DPP Planning

Ref: 4124LE.L005.A

Date: 21 October 2022

2022/0194 PROPOSED LIDL STORE AT LAND TO THE NORTH OF SHEFFIELD ROAD, HOYLAND

Drawing Title
PROPOSED ELEVATION - OPTION 2

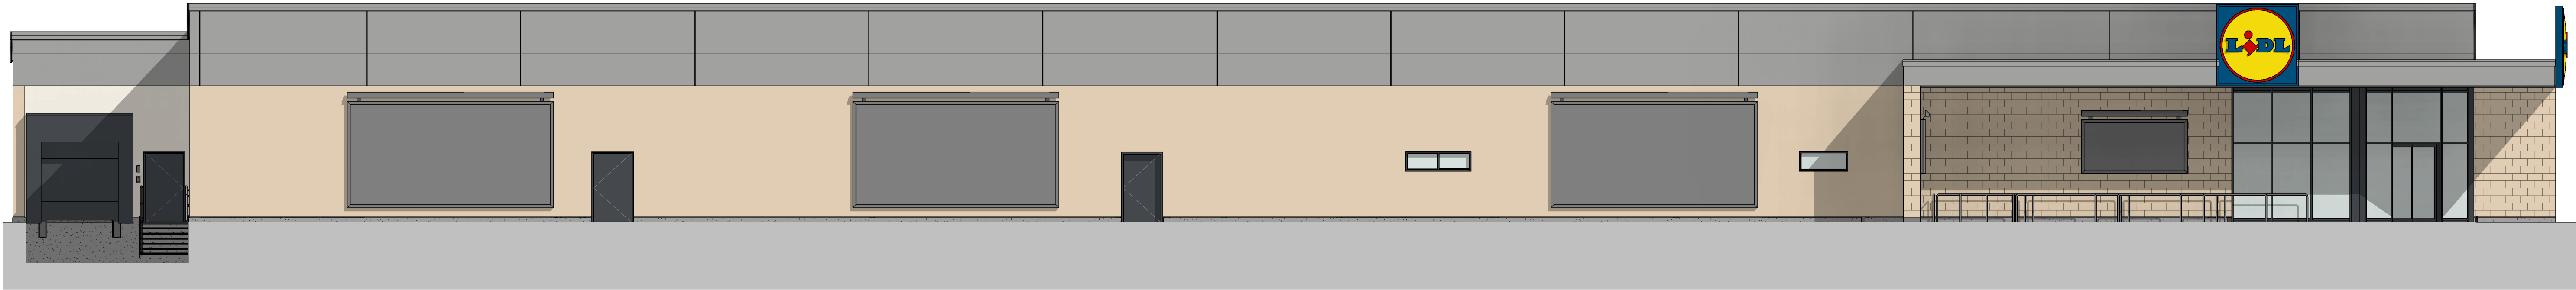
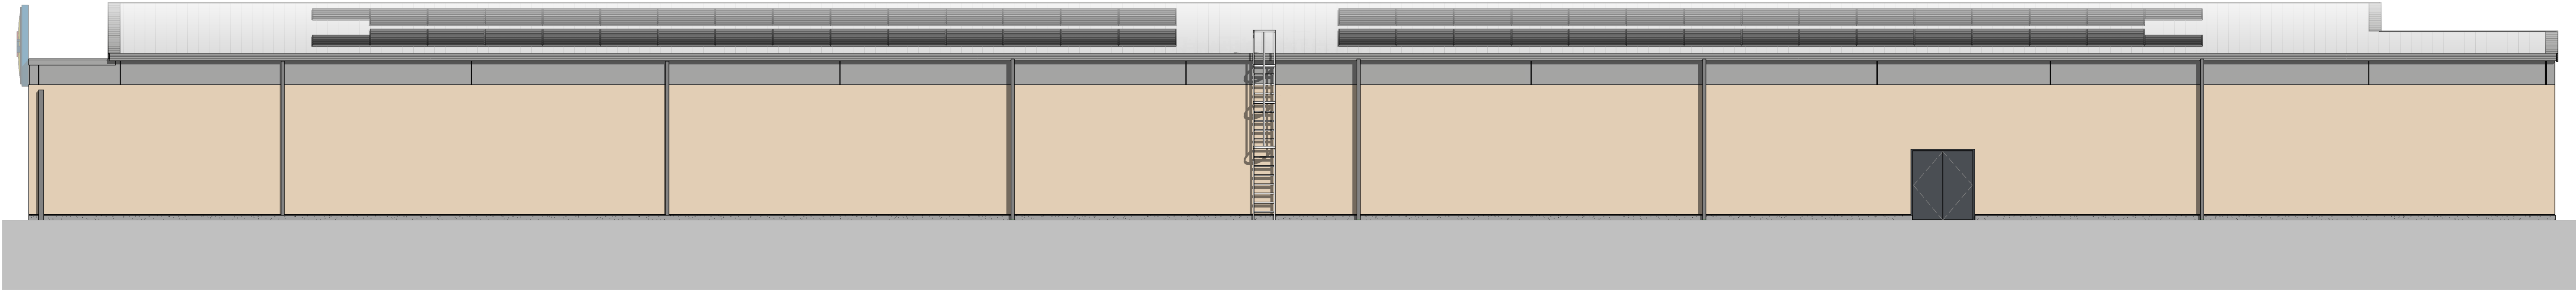
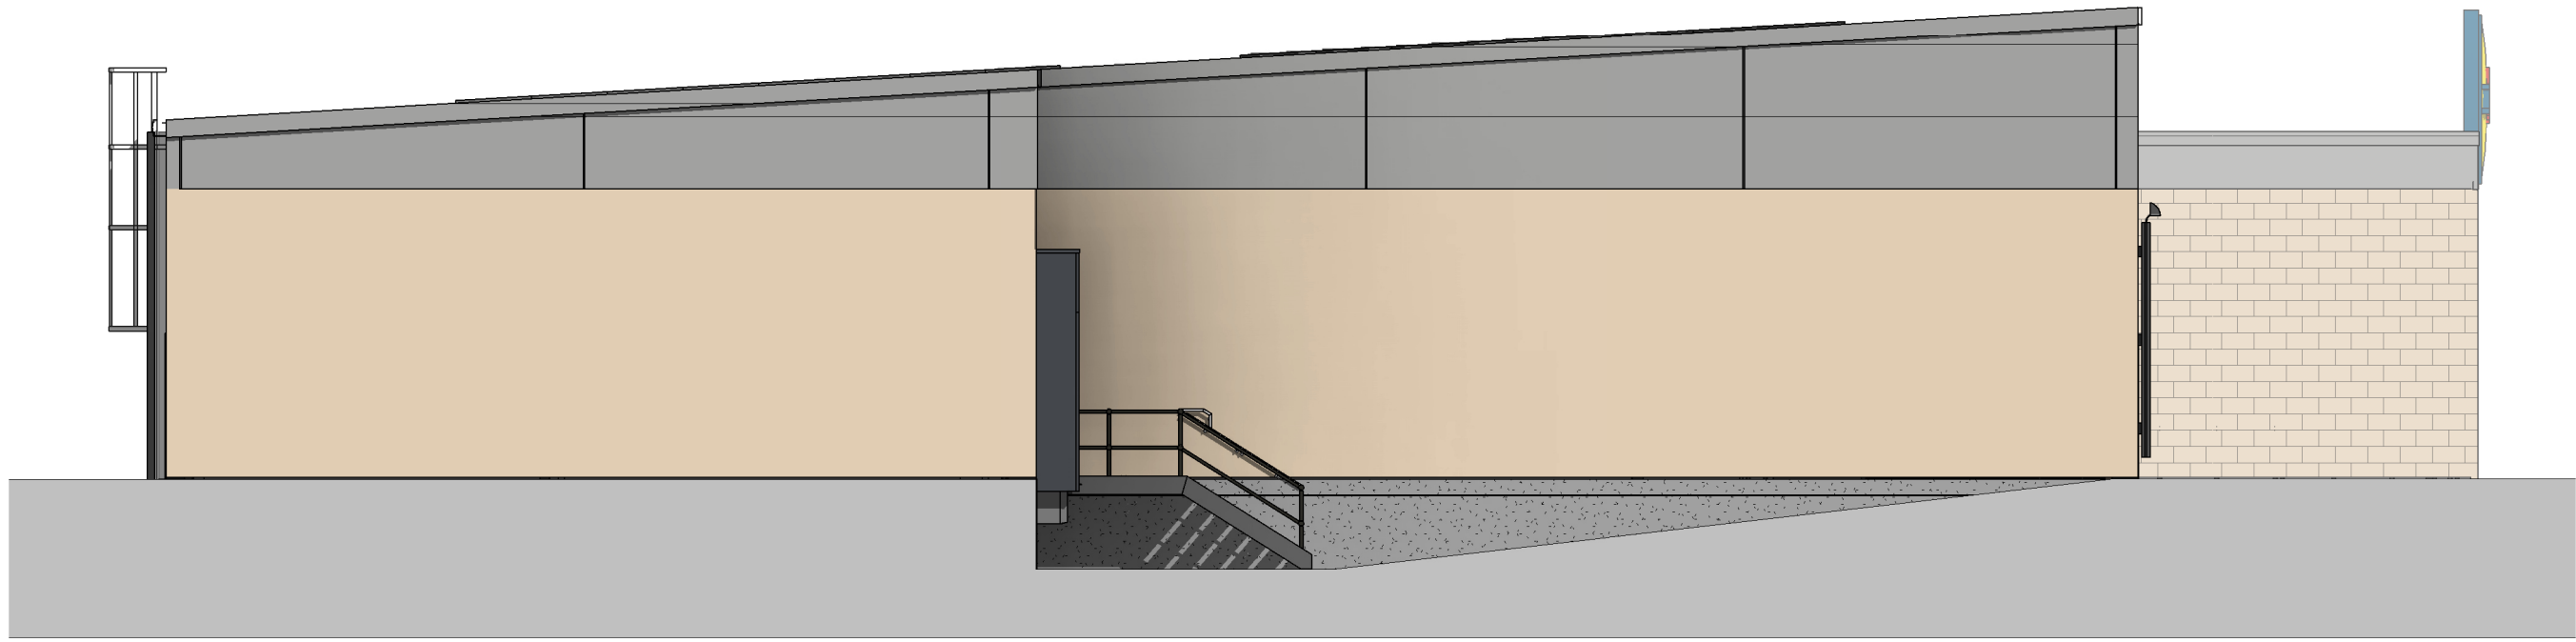
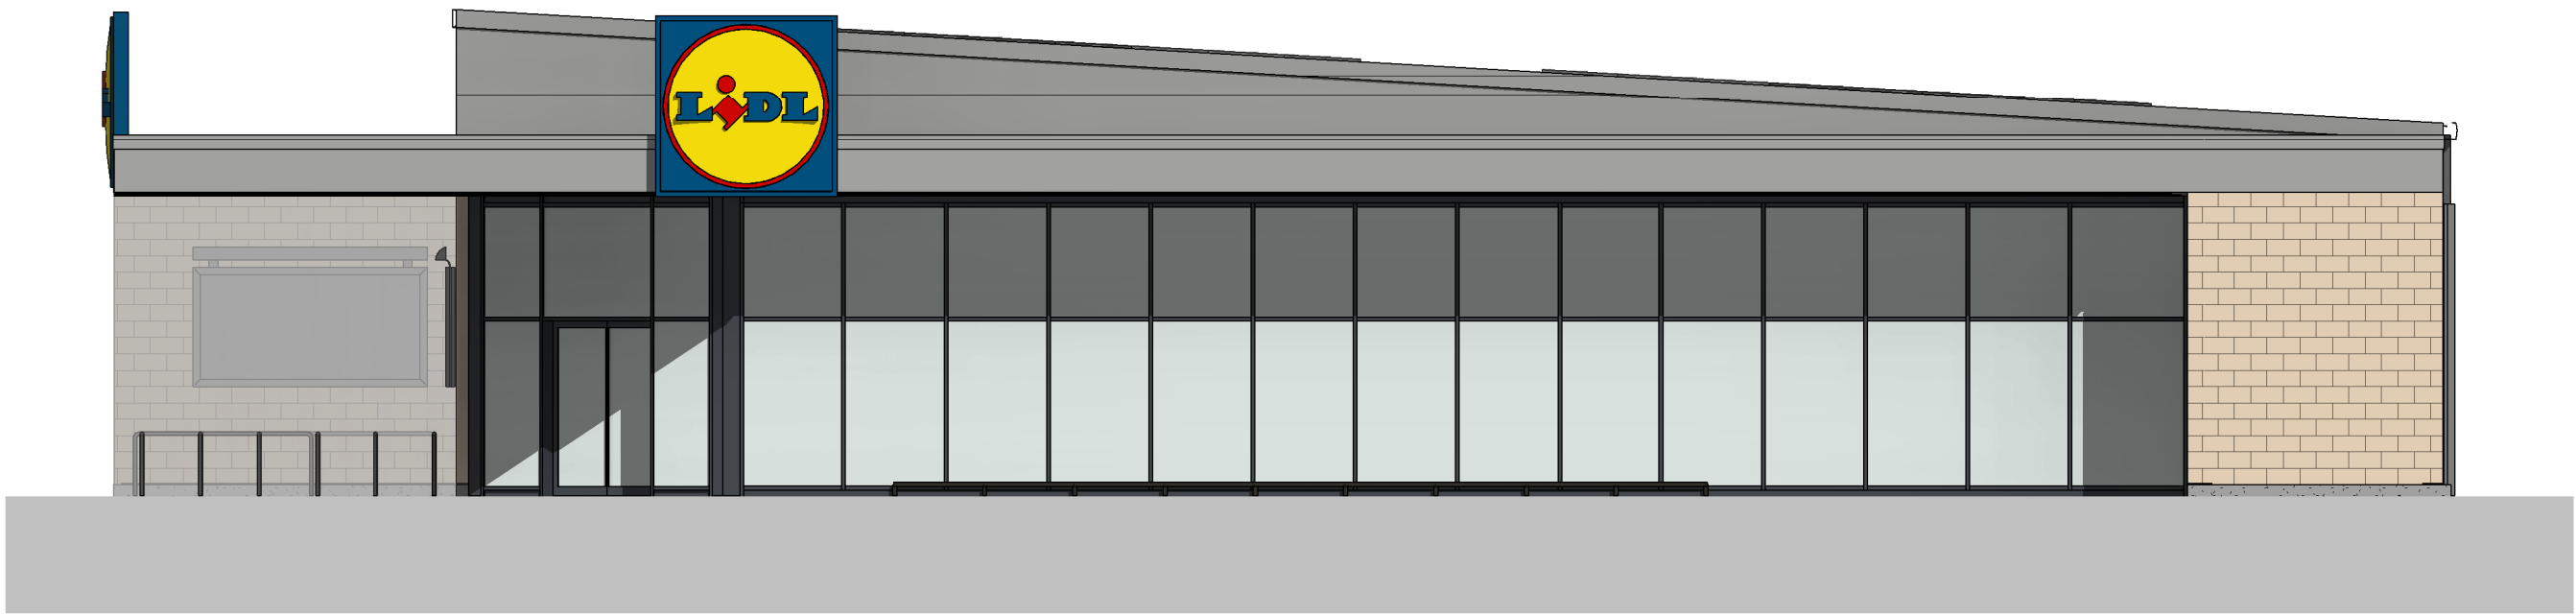
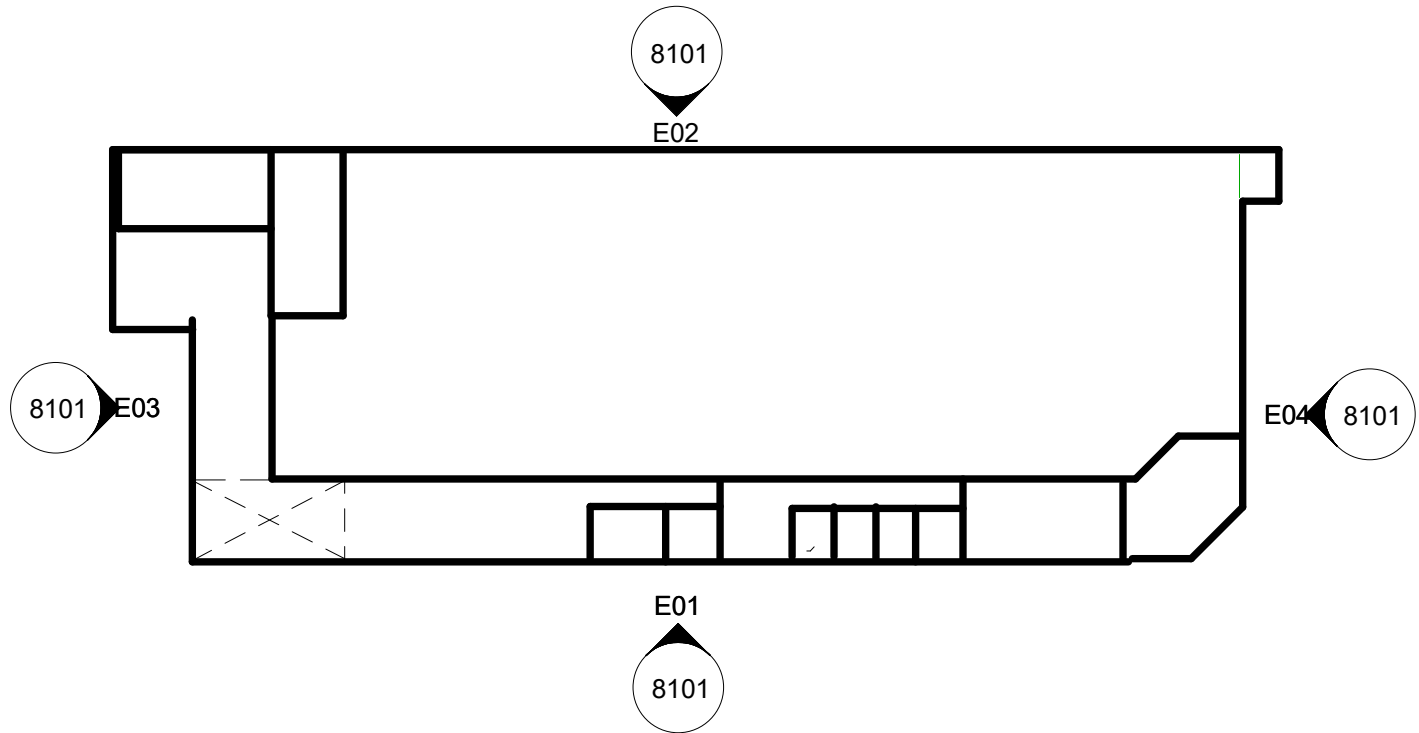
Elevations

The elevations of the store have been updated following design comments from the Council. Whilst the general form of the Lidl unit remains the same, the elevations now reference local materials, utilising stone and render to create a design more suitable to a location BMBC view as prominent.
